Planning Application Ref: FP/84/19/DOC

Location: Blakes Mead Felpham Bognor Regis, West Sussex

Description of works: Approval of details reserved by condition imposed under reference FP/92/04 for Phases 1, 2, 3, 4 and 5 relating to Condition Nos 30 - provision of play areas; 32 - maintenance of open space; **33 - tree protection measures**; 34 - maintenance of planting; 42 - archaeology; and 46 - provision of cycle paths

BDWS19795-03B

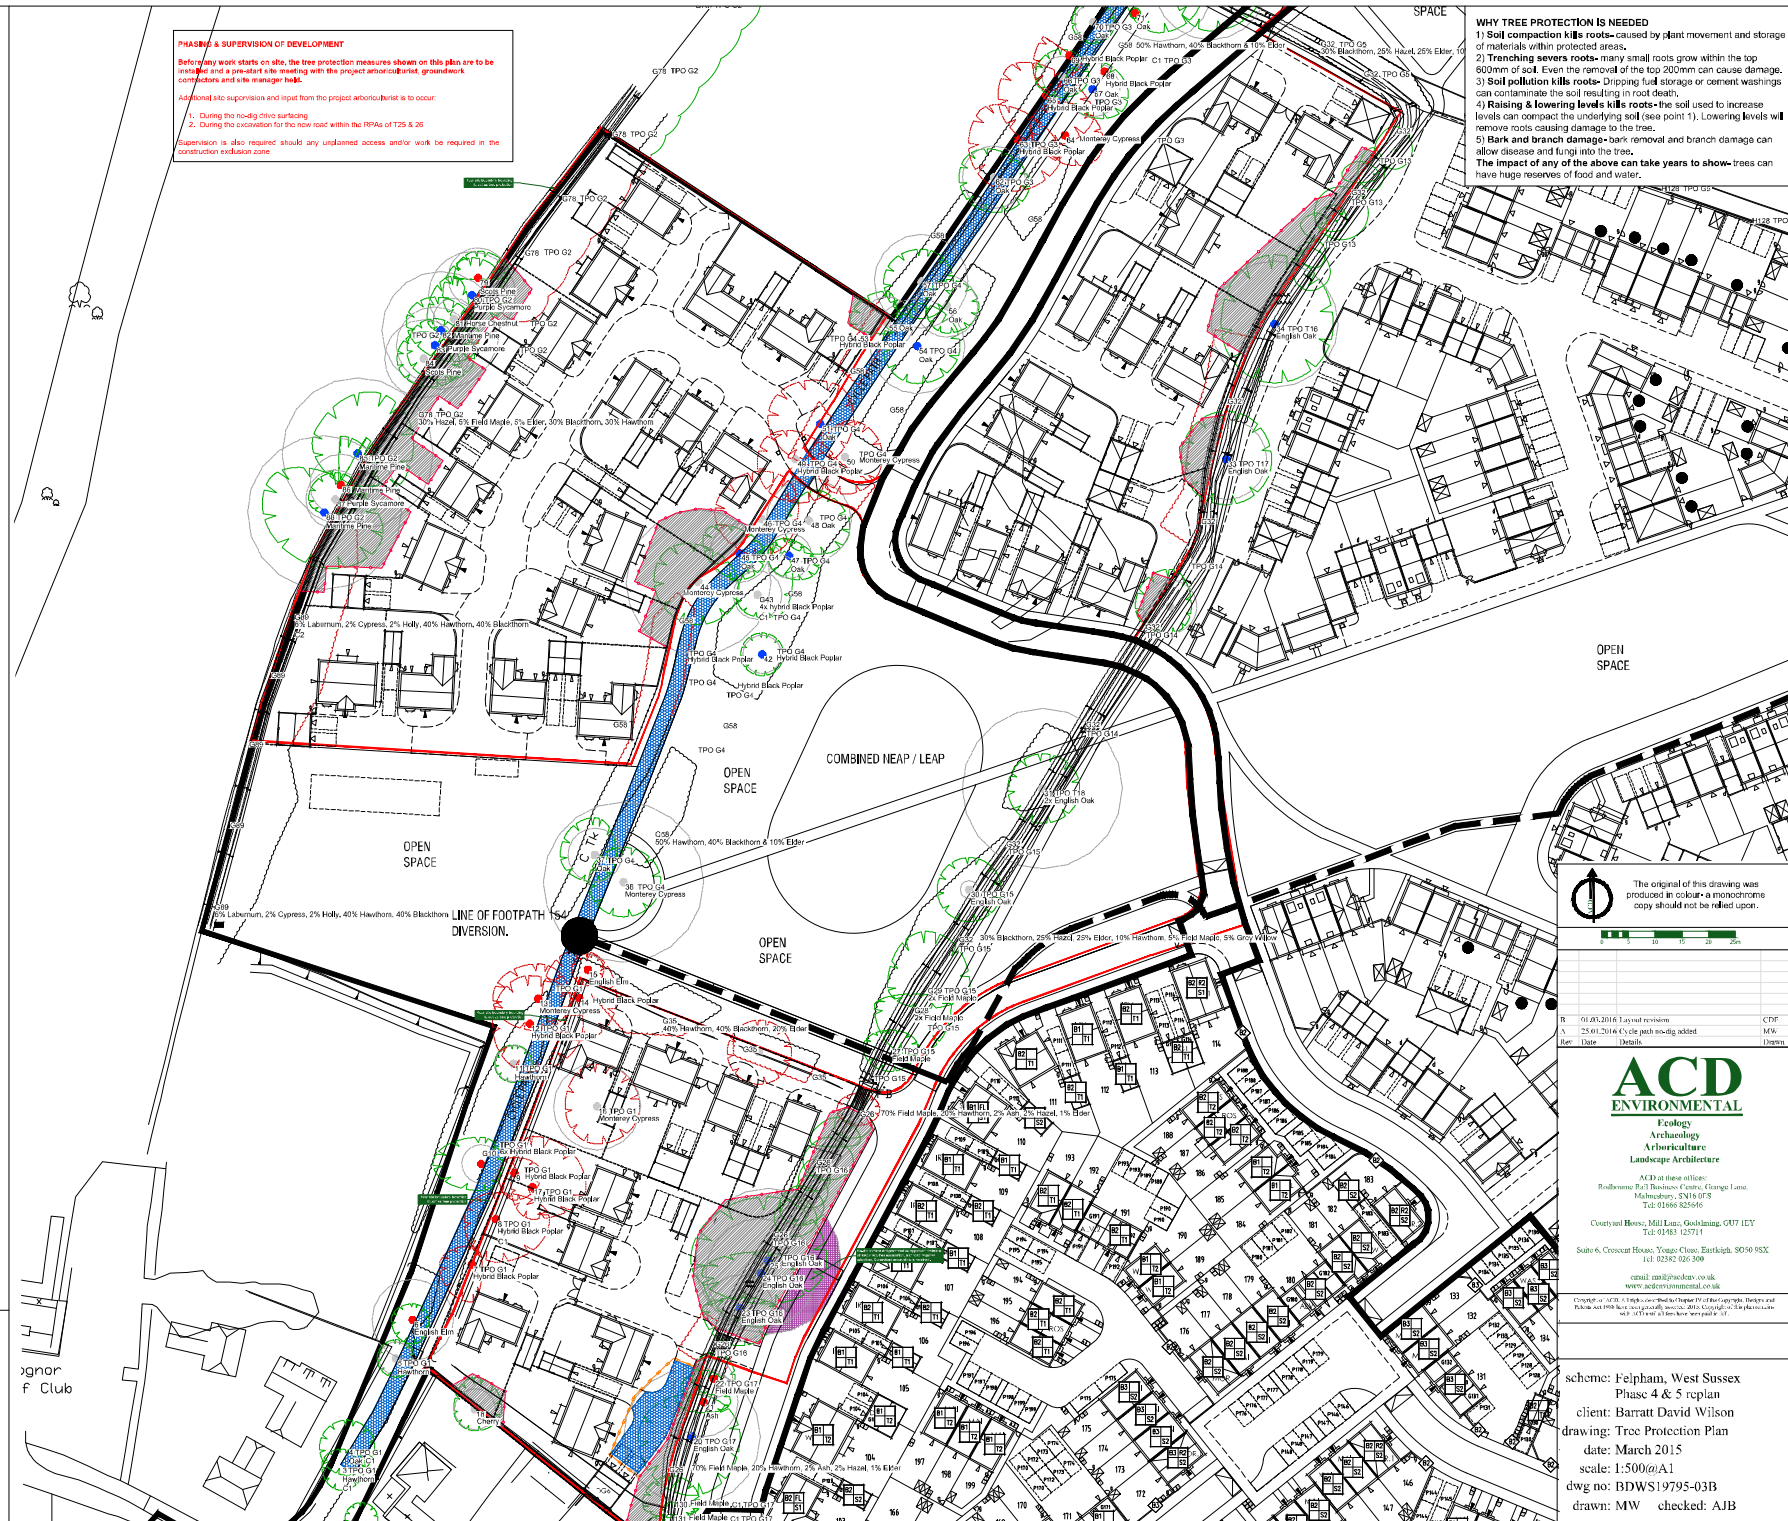
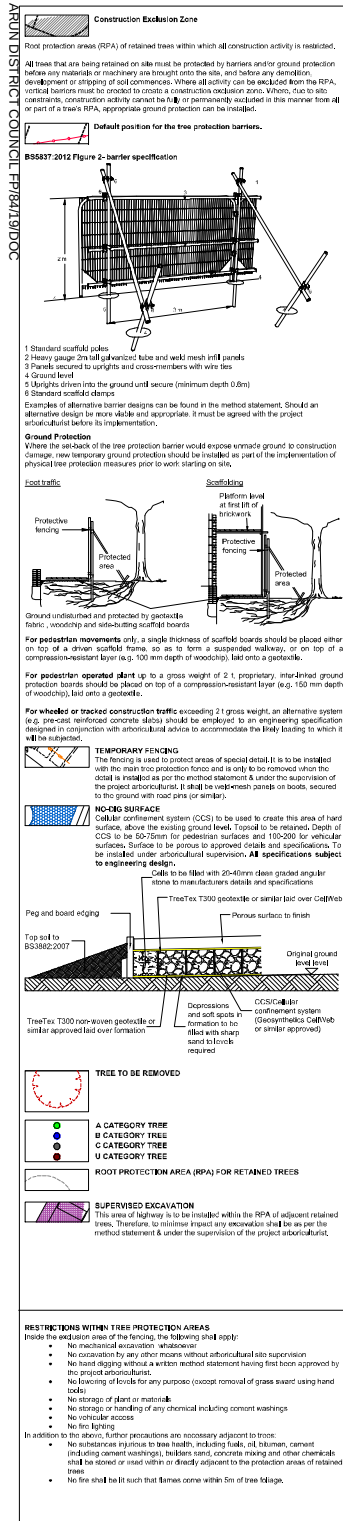
- We have been provided with an arboricultural report and method statement which is approvable although I have only had sight of one tree protection plan for phase 4 and 5, in support of this application. On this rather moot point, their submission overall fails to constitute an approvable scheme of protection for all phases of the site.
